# CITY OF ALBUQUERQUE

**Re: Gate of Heaven Cemetery  
Site Grading Plan  
Engineer's Stamp dated 3-26-12 (D19/D001A)**

**Re: Gate of Heaven Cemetery  
Site Grading Plan  
Engineer's Stamp dated 3-5-12 (D19/D001A)**

PROJECT NUMBER 0702
DRAWN BY T.E/SEJ
CHECKED BY KRB
ISSUE DATE 1-9-12
FILE NAME: 0702_C-103_SITE GRADING PLAN
SHEET NAME
SITE GRADING PLAN
SHEET NUMBER
C-103

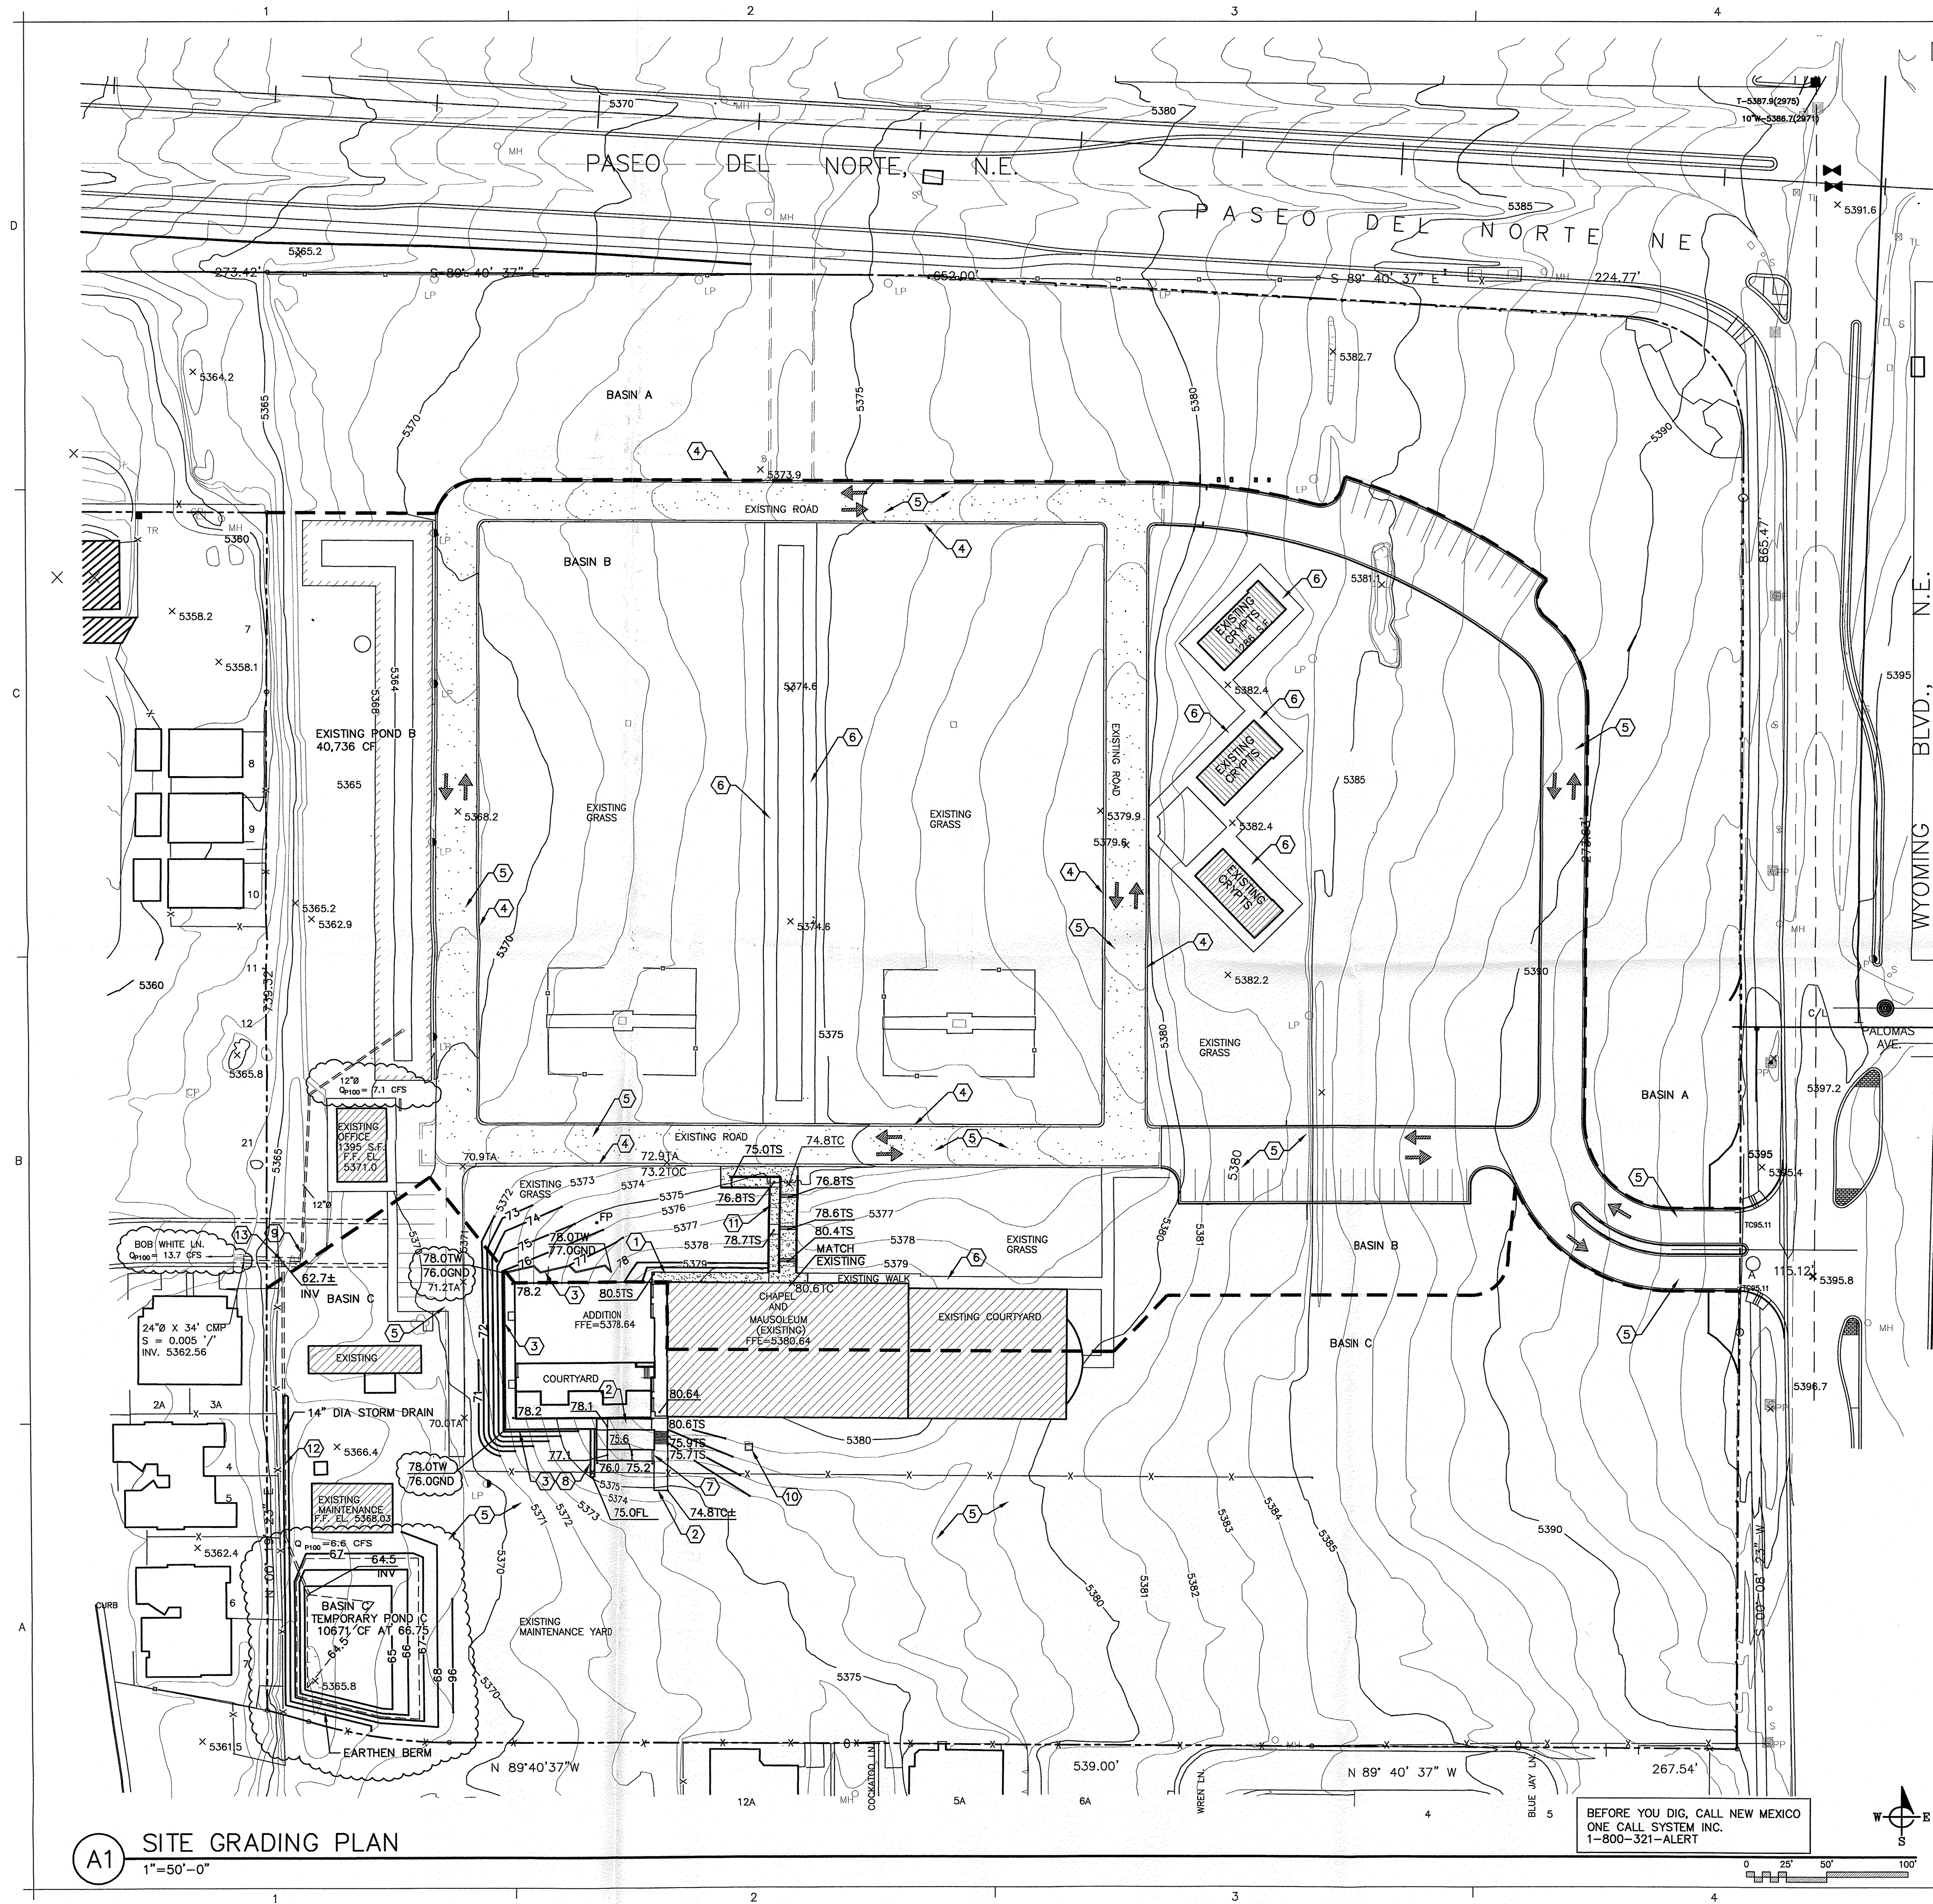
- Per approved grading plans dated 6/4/2002 and 11/21/94 ponds B & C drained into Bob White Lane at a rate of 13.7cfs. This rate should remain unless it is proven that the rate of 24.2cfs will not cause adverse effects to the drainage system in Bob White Lane.
- Provide discharge calculations for pond C.

I have received your letter of March 26, 2012. The drainage plan has been revised to limit the combined discharge to Bob White Lane at 13.7 cfs. The discharge from the existing pond B (7.1 cfs) has been corrected on the grading plan. The design of pond C has been revised to limit the rate of discharge from Basin C to limited to 6.6 cfs.
